From: Simon Davis
Sent: 07 September 2018 09:44
To: [REDACTED]
Subject: RE: Update on application FP/171/18/PL

Subject: RE: Update on application FP/171/18/PL

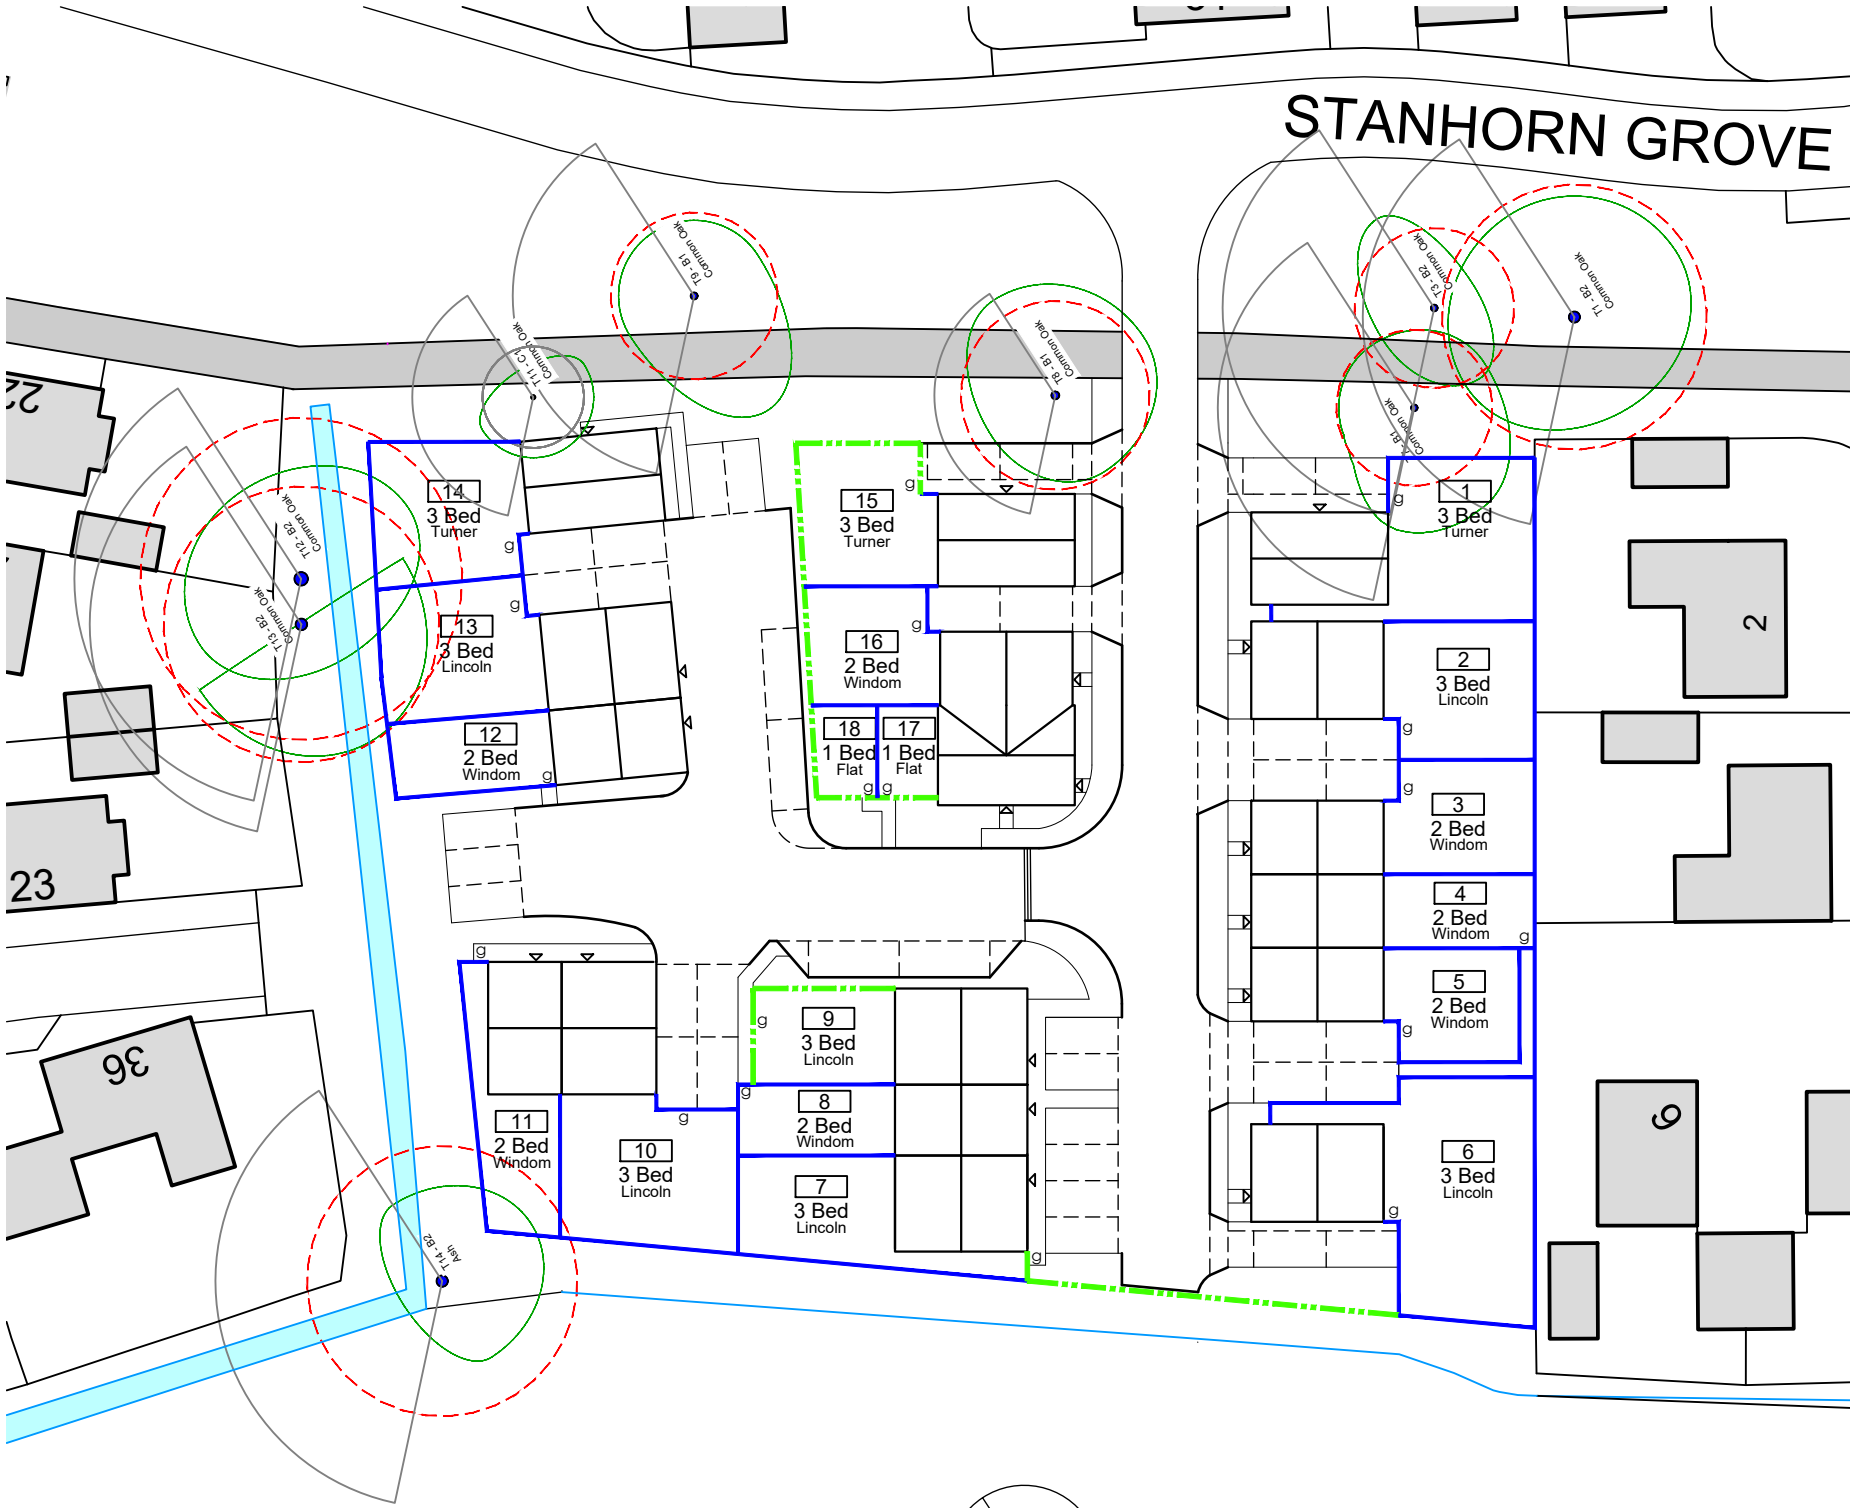
- (1) Can you amend drawing 17094-PL-2-07 (and any related drawings) to show brick walls/brick & timber panels to the fronts of plots 1 and 14 as per plot 15.

- (2) The interface distance between the rear of plots 3-5 and the rear of 4 Weller Close is a bit tight. Can you move plots 3-5 forward by 1m at the expense of part of the front landscaping strip.

Client	MJA CONSULTING CIVIL AND STRUCTURAL ENGINEERS Monarch House, Barton Lane, Abingdon, Oxon, OX14 3NB Tel: 01235 555173 Fax: 01235 523226		
Project	Felpham		
Title	Engineering Layout	Scale 1:200@A1 Checked KTG	Date Mar'18 Drawn JRV
Drawing No.	5782:01	Rev C

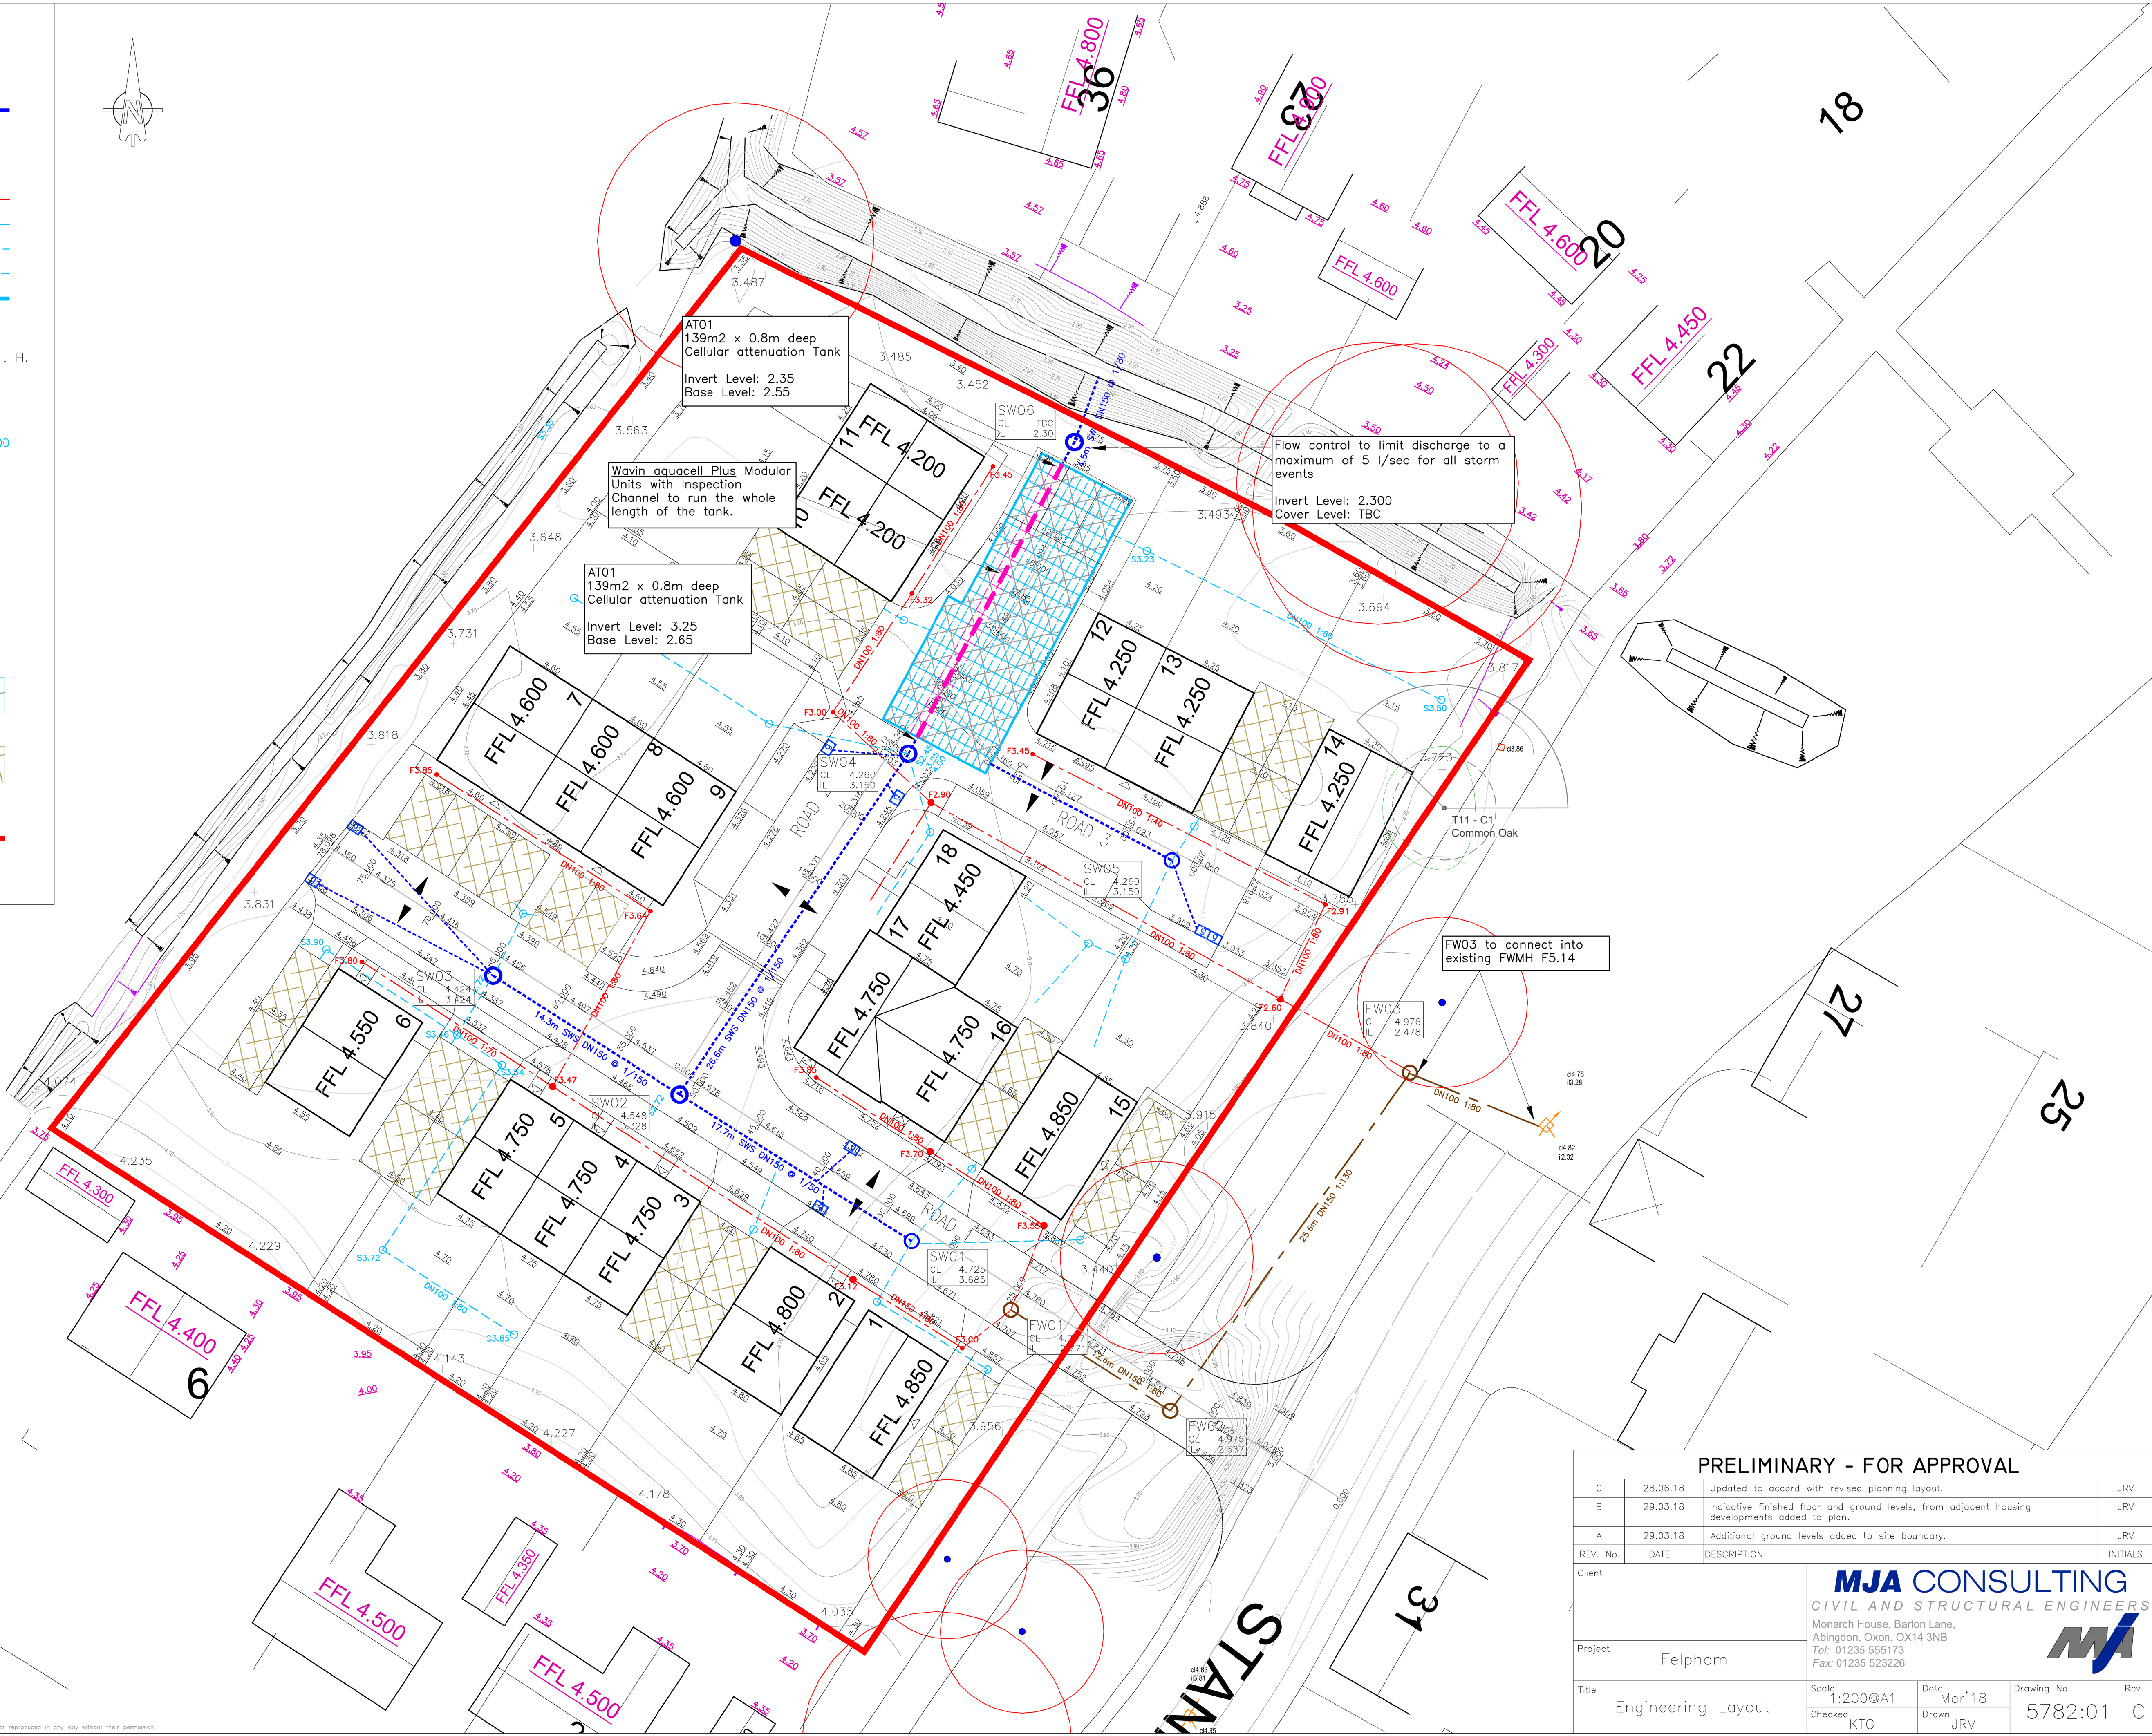
We need a drawing showing existing & proposed spot levels – I appreciate this information is shown on the drainage plan but it will be easier for us to assess if we have a plan just showing levels
